Planning Application Ref: Y/91/17/OUT

Location: Land at Bilsham Road, Yapton

Description of works: Outline application for the development of up to 250 residential dwellings (Class C3) vehicular access, public open space, ancillary works and associated infrastructure. Departure from the Development Plan

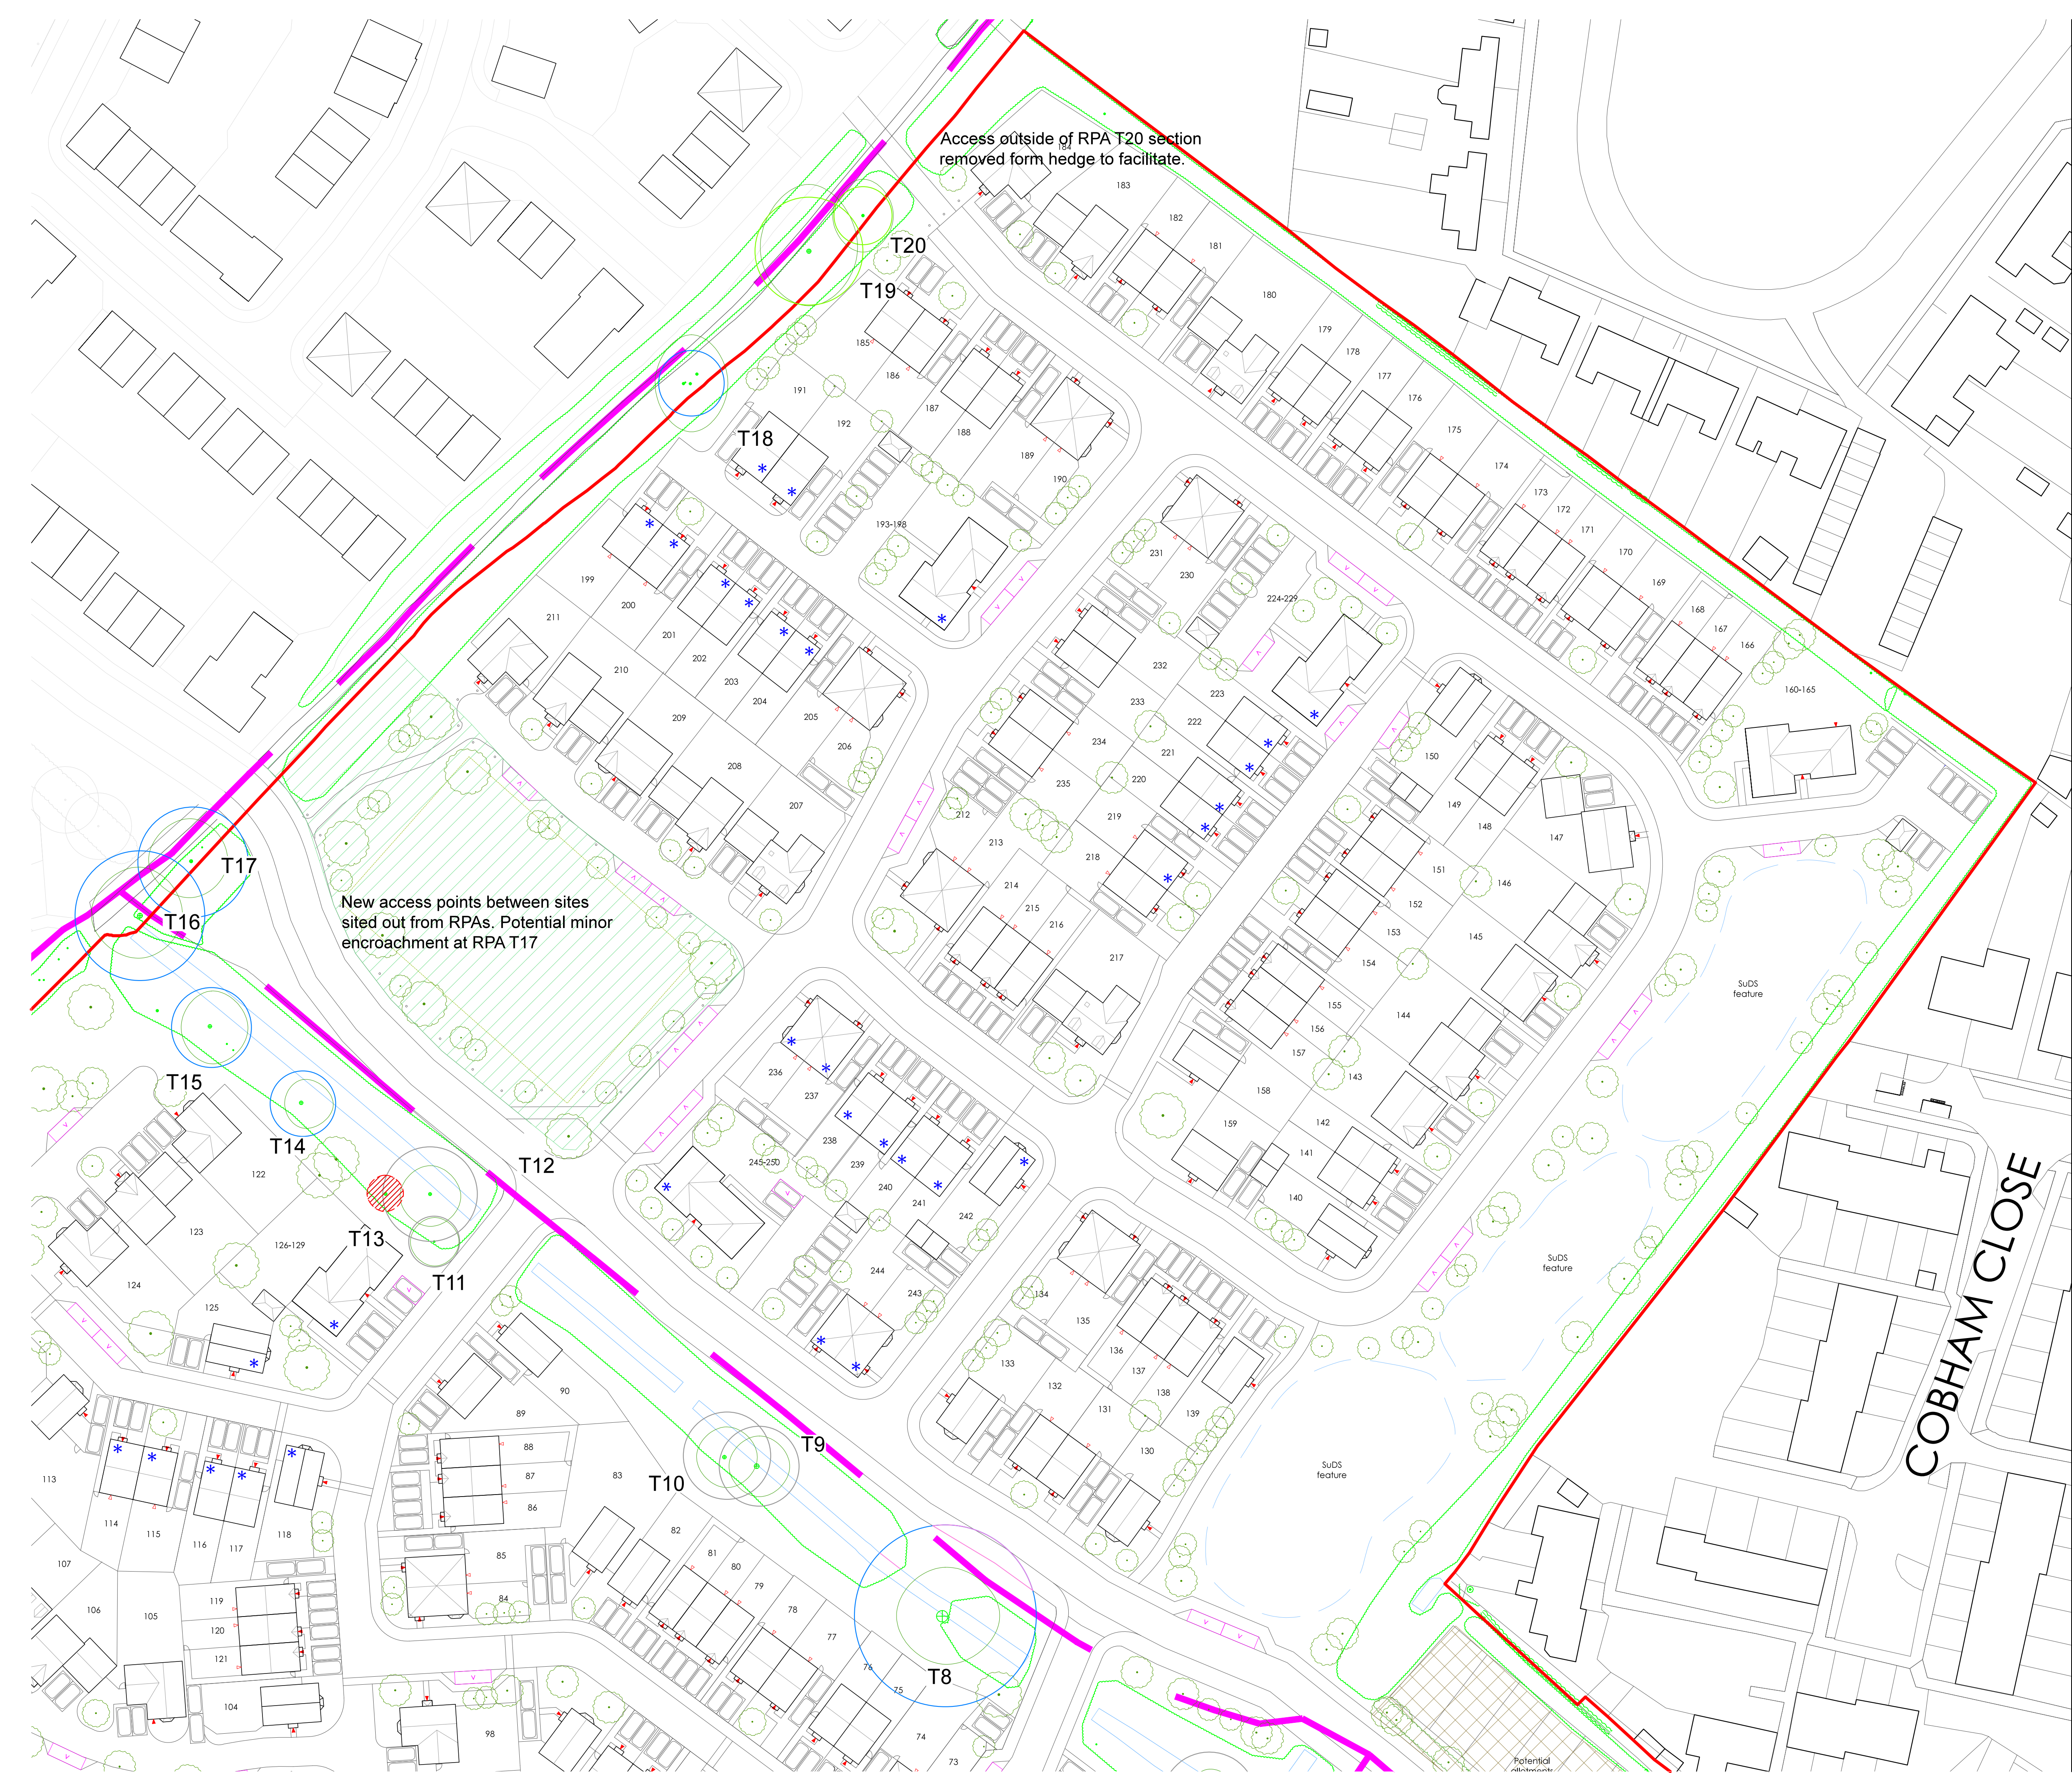
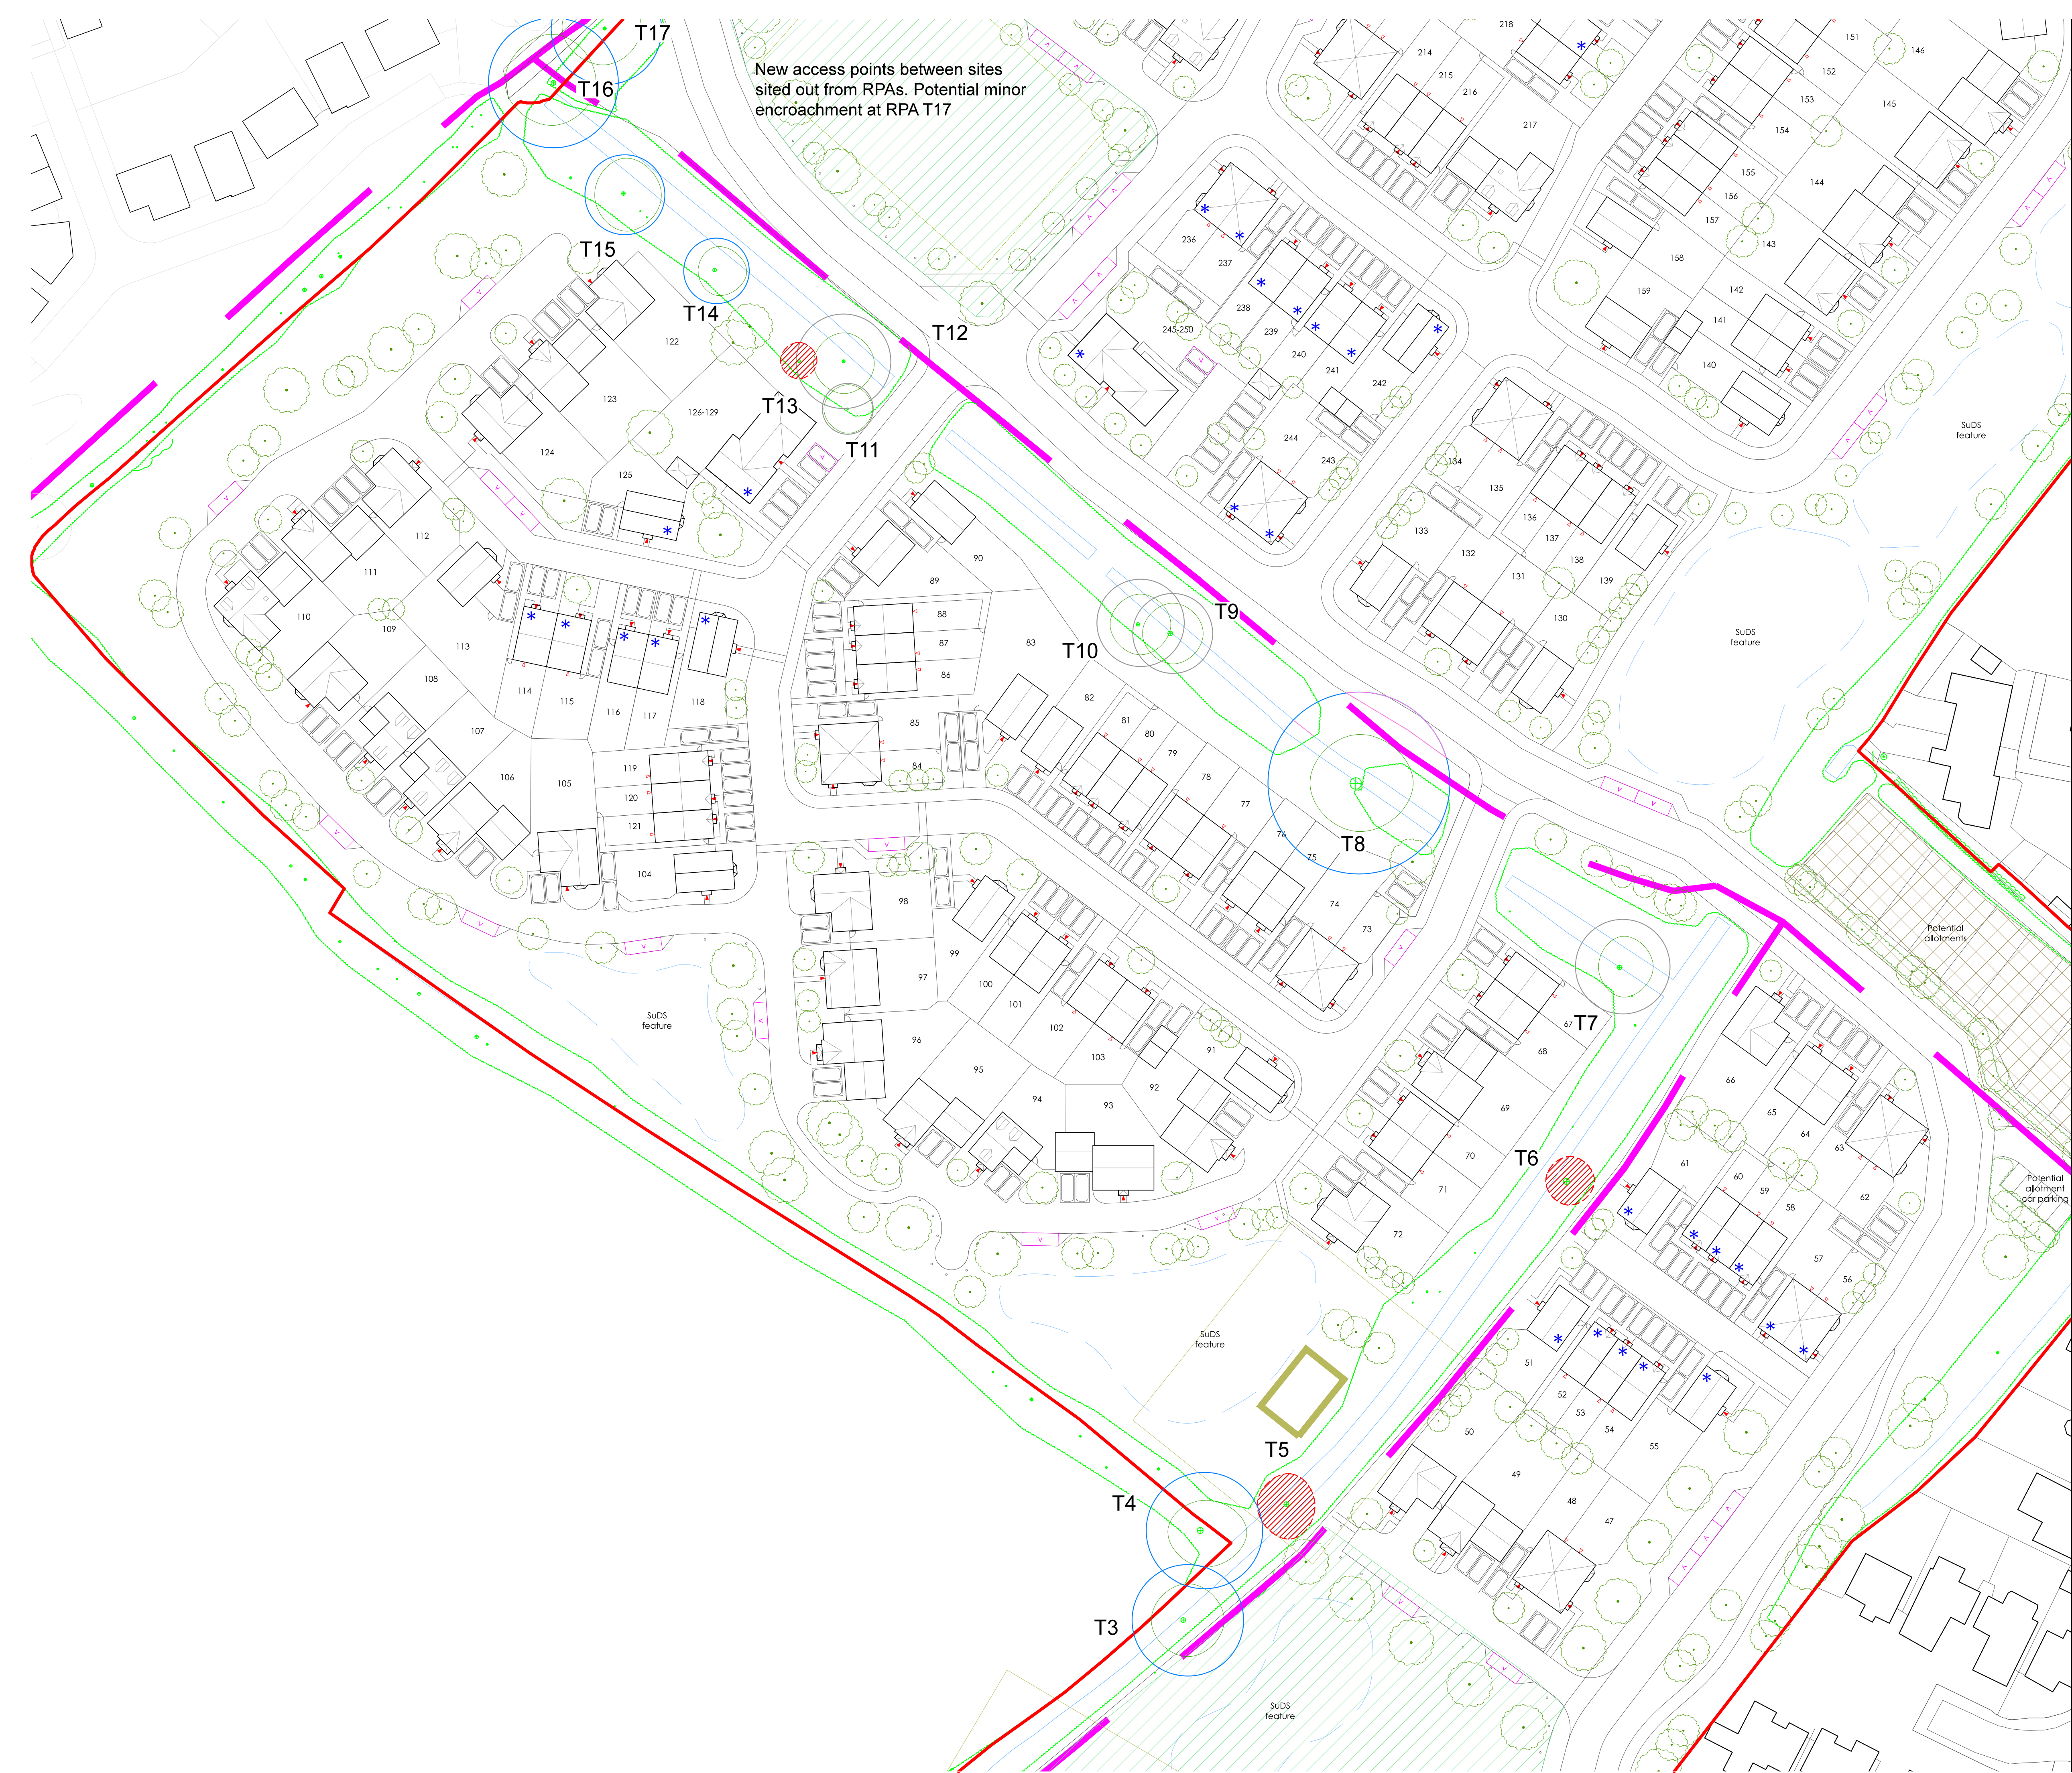
- The applicants employed the PJC Consultancy back in November 2017 to undertake a tree survey and then prepare an Arboricultural Impact Assessment (AIA) PJC/4699/17-02 R2. Tree Survey data is adequate at this stage and broadly accords with the requirements of BS5837:2012. I have referred to Illustrative detailed masterplan drg. 1244G.03 to assist with determining the accuracy of the Tree Constraints and Tree Retention Plans submitted by PJC with their AIA report. This allows me to gain a general understanding of how the plot layout and access routes relate to trees but is not specific enough for me to have full confidence they will be adequately respected and protected.

- The site contains a number of significant trees, both within and along most aspects of the site perimeter. These have already attained considerable landscape value and have potential to provide a long-term aesthetic contribution to the proposed development. **The stem diameter readings (an important factor informing the appropriate extent of RPA) are reasonably estimated but many of the tree heights are substantially underestimated and retention categories suggest an inclination to demote their status.**

- At this outline stage, the indicative layout and access arrangements and the appointed arboriculturalist's general regard for significant trees existing on site are encouraging and I am in broad agreement with their survey information. That said, I am concerned that there appear to be notable omissions in respect of existing tree cover along several sections of the site perimeter (South, adjacent arable farmland – East, rear of The Millers – North, south of dwellings at Tack Lee Road). This may be deliberate as the proposed design does not at this stage suggest any direct interference with them but it is important to consider all trees whether they are on or off-site and within potential influencing distance, so as to inform the site layout design which may of course be subject to revision. Any omissions will need to be addressed and therefore included in the aforementioned TPP and AMS should this proceed to a full planning application. **Despite appearing in symbolic form on the Illustrative detailed masterplan drg. 1244G.03, significant trees located within the Southern site perimeter hedgerow were omitted from the tree survey schedule provided by PJC. They are of such dimensions and proximity as to be a material consideration and will require inclusion in any subsequent TPP and appropriate levels of protection before any work can commence on site. I have determined that the majority of these merit a TPO.**

ecological value. For it to be retained satisfactorily within the development, the proposal to 'cap' the RPA at 15m radius should be re-visited to prevent any disturbance to the root system and provide this tree with the room to endure without coming under pressure for hazard abatement pruning work. Such work would reduce its ecological and habitat value greatly. The current proposal to install a footway within the North sector of the RPA (despite the suggestion of 'no-dig' construction methodology) and position a private garden beneath the crown spread on the South aspect are clearly incompatible with these objectives.

- I am pleased to see there is intent to retain the vast majority of recorded trees in harmony with the development, but I cannot be satisfied that this will be achievable until we receive a Tree Protection Plan (TPP) overlaying the final proposed site design layout, with supporting Arboricultural Method Statement (AMS) where RPA (Root protection area) incursion is anticipated - which I would expect to see submitted with a subsequent full planning application.
